Re: **Girder Truss Issue**
Location: Lot 235 Serenity (12 Charming Ct. Fuquay-Varina, NC)
JDS Project No.: RDU2400202
Date of Inspection: 1/8/24

A representative of JDS Consulting arrived on site to observe the issues reported to us by the client, which are presented, along with our recommendations, in this report.

2.04
 Roof Plan
 Elevation "A"

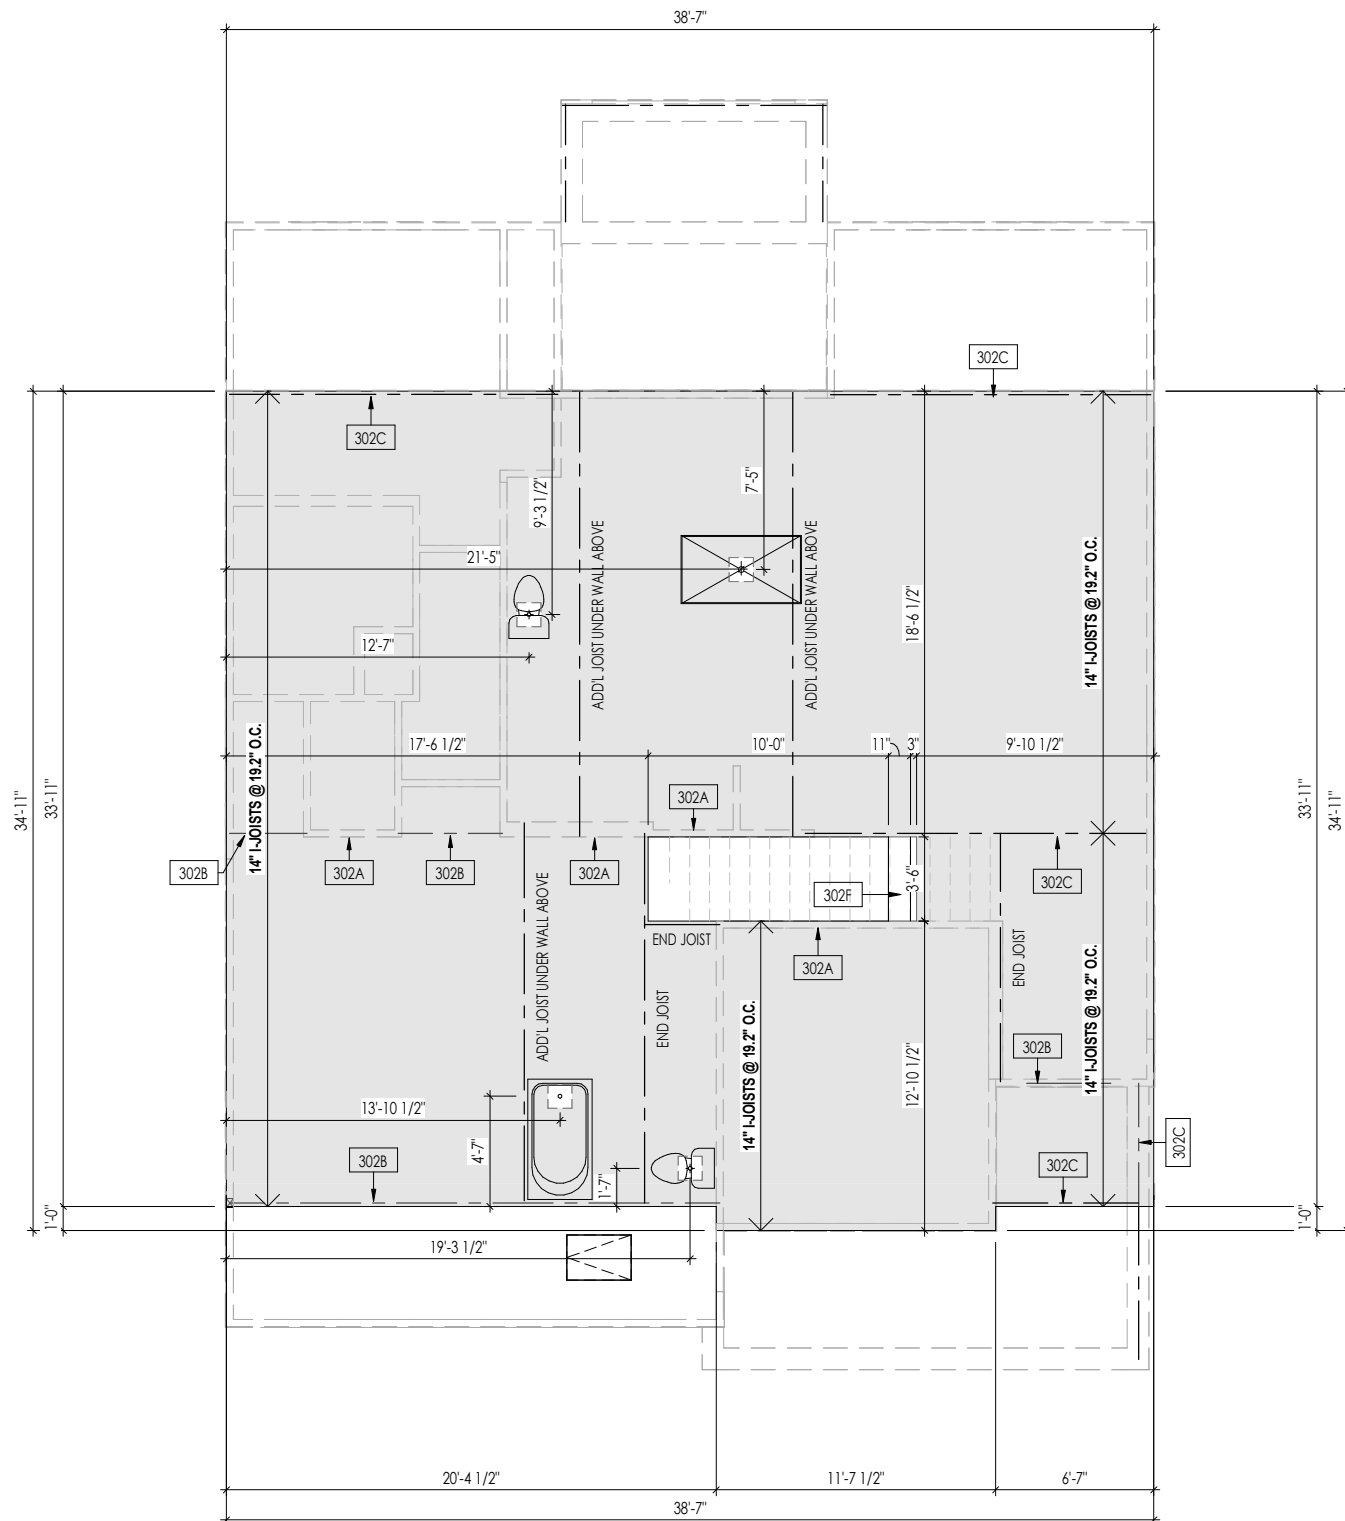
The client has requested evaluation of the (3) T03 trusses and (2) T04 trusses being hangered into a 2x8 scab attached to the rear face of the bottom chord of the G01 girder truss. The 2x8 scab has been attached with random nailing pattern.

Based on our onsite observation and review the contractor shall ensure the 2x8 scab is attached to the G01 girder truss bottom chord with (3) rows of 10d nails 6" O.C.
